PLANNING COMMISSION STAFF REPORT

SUBJECT: Crowe Preliminary Plat (P-07-51)

The Crowe Preliminary Plat is an application for the division of one parcel totaling approximately 22.57 acres into a total of 7 lots ranging in size from 3.00 to 3.78 acres, submitted by Chuck Cruse of Cruse & Associates, authorized agent for Robert Crowe, landowner.

**CROWE PLAT  
PART OF SECTION 8, T. 17 N., R. 18 E., W.M.  
KITITAS COUNTY, WASHINGTON  
- PRELIMINARY PLAT -**

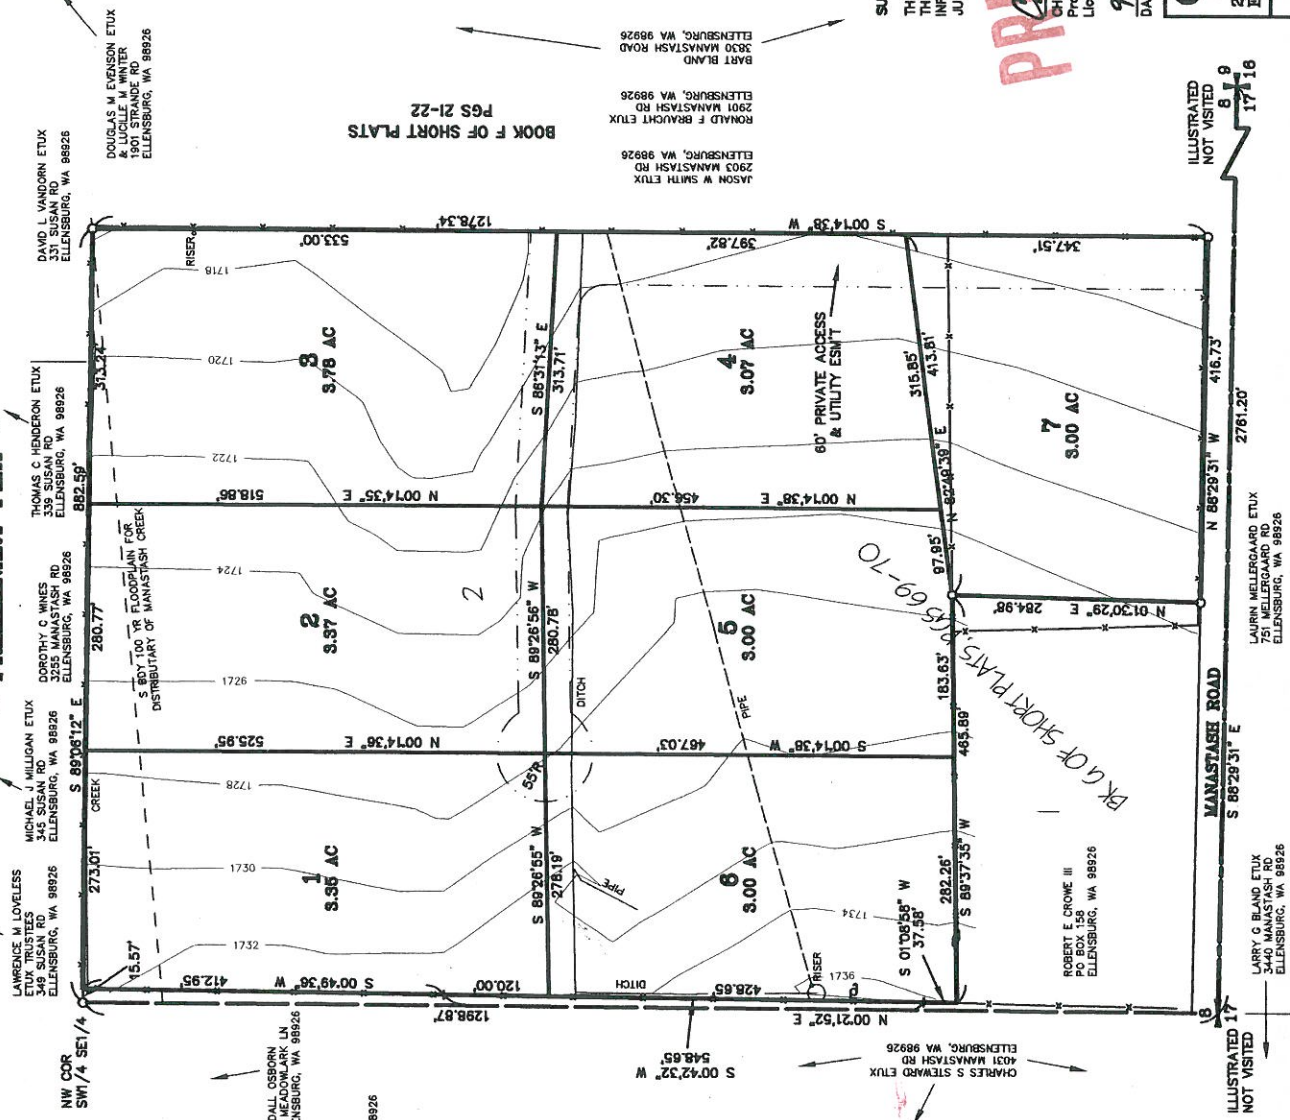
Environmental Health: The applicant has proposed individual wells and septic systems for this project. Due to comments from the Washington State Department of Ecology and Kittitas County Environmental Health, the applicant will be required to develop one "Group B" water system to serve all seven lots, as a condition of final plat approval. The SEPA MDNS from the Crowe Rezone also states, "Available water supplies on site may not support a higher density development than [sic] is currently allowed under the Agriculture-20 zoning."

Critical Areas: An administrative site analysis was completed by Community Development Services in compliance with Title 17A. The northernmost portion of lot 1, lot 2, and lot 3 are partially located in the 100-year floodplain. This will need to be evaluated at the time of submittal of a building permit for any of these 3 lots. There are no additional critical areas located on the subject property.

9. The applicant will develop a "Group B" water system to serve all seven (7) lots of the plat. The required "Group B" system shall be in place and approved prior to final plat approval. Flow meters must be installed both at the well head and on each individual lot. Records documenting

10. A plat note shall be added to the final mylars reflecting the requirement of the "Group B" water system. The note shall read as follows:

A single "Group B" water system shall be constructed to serve all seven (7) lots of the Crowe Preliminary Plat (P-07-51). Flow meters must be installed at both the well head and on each individual lot. Records documenting water usage both at the well head and on each individual lot must be maintained and available for public inspection by a Satellite Management Agency (SMA).
